Online Comment

Application H16-0067-24
Location 11 MARKET PLACE SPALDING PE11 1SP
Proposal Replacement of degraded timber sash windows with new double glazed timber windows and replacement entrance door - Part retrospective

Name Spalding & District Civic Society
Address 36 Park Avenue Spalding Lincs PE11 1QX

TITLE
Existing South East Elevation

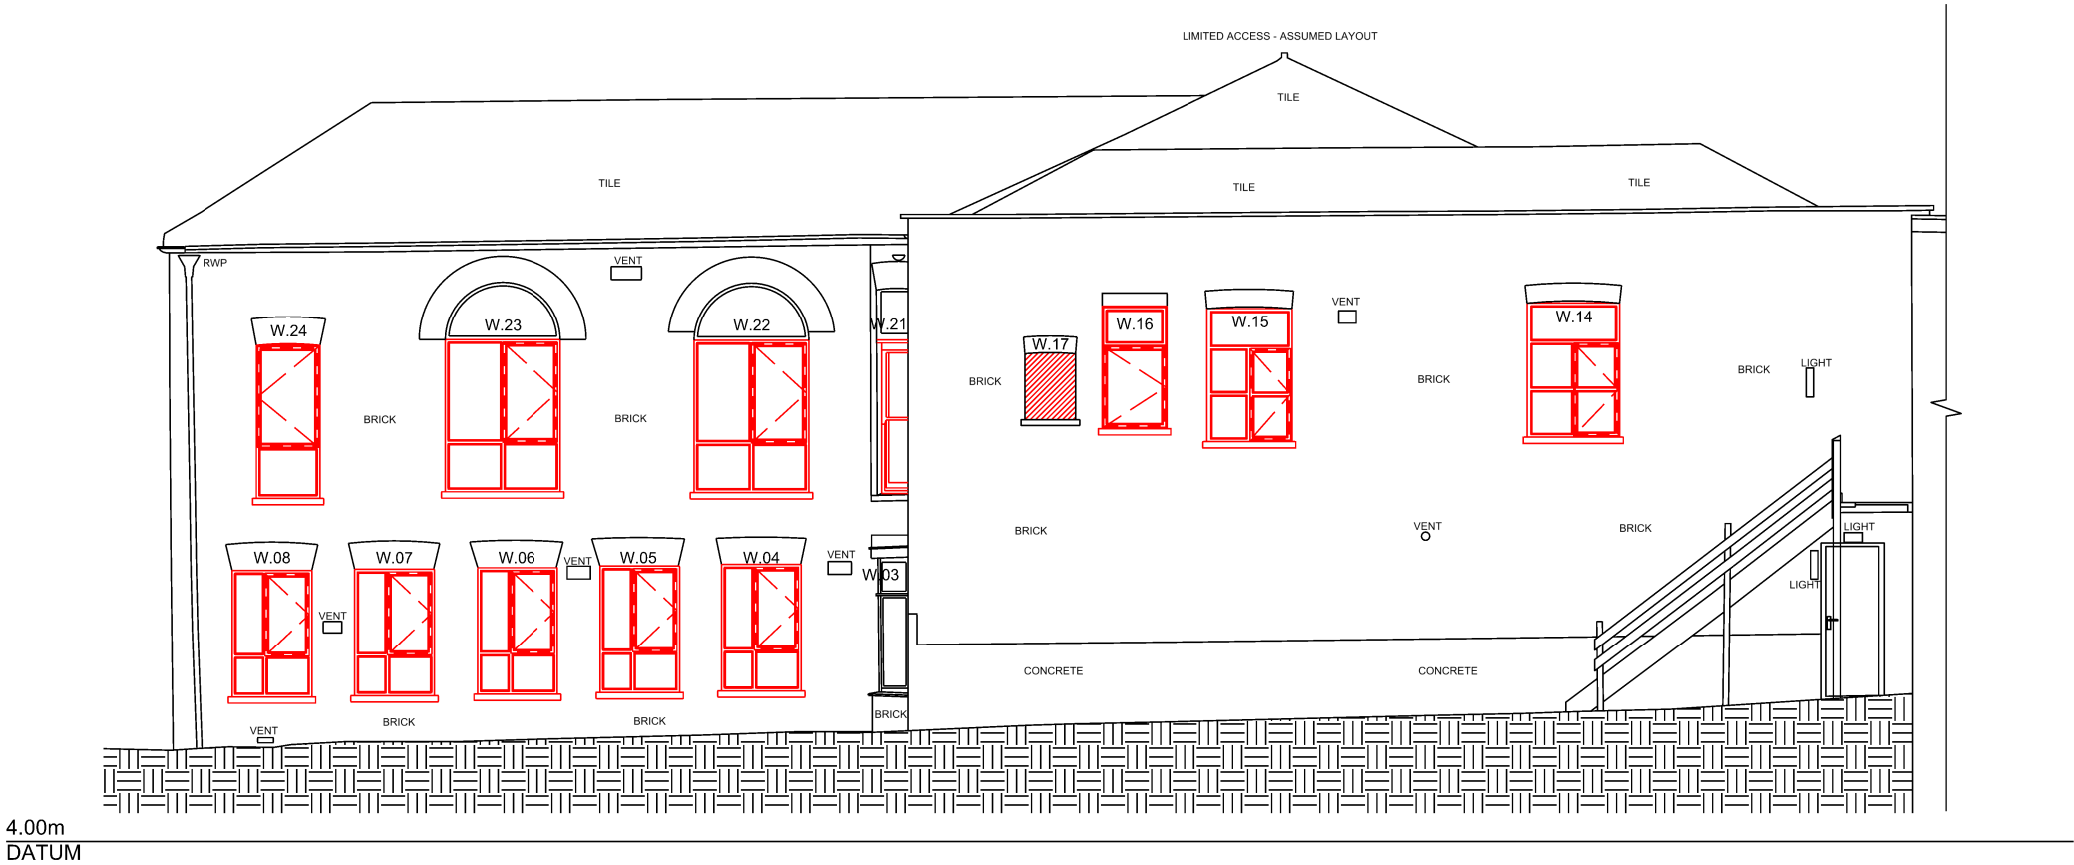
We note that it is proposed to replace some of the wooden framed windows with double glazed units and repairing others. The applicant does not indicate which will be replaced.

Whilst the proposed designs do not significantly differ from the existing windows, and this is to the rear of the building, there are alternative solutions that could be considered by following guidance issued by Historic England. As Historic England is a statutory body, we would hope that their guidance has the same weight as local and national planning policy.

Therefore we ask whether the applicant can reconsider the proposal and where repair is not an option, undertake a like for like replacement using traditional materials that are likely to have a longer lifespan.
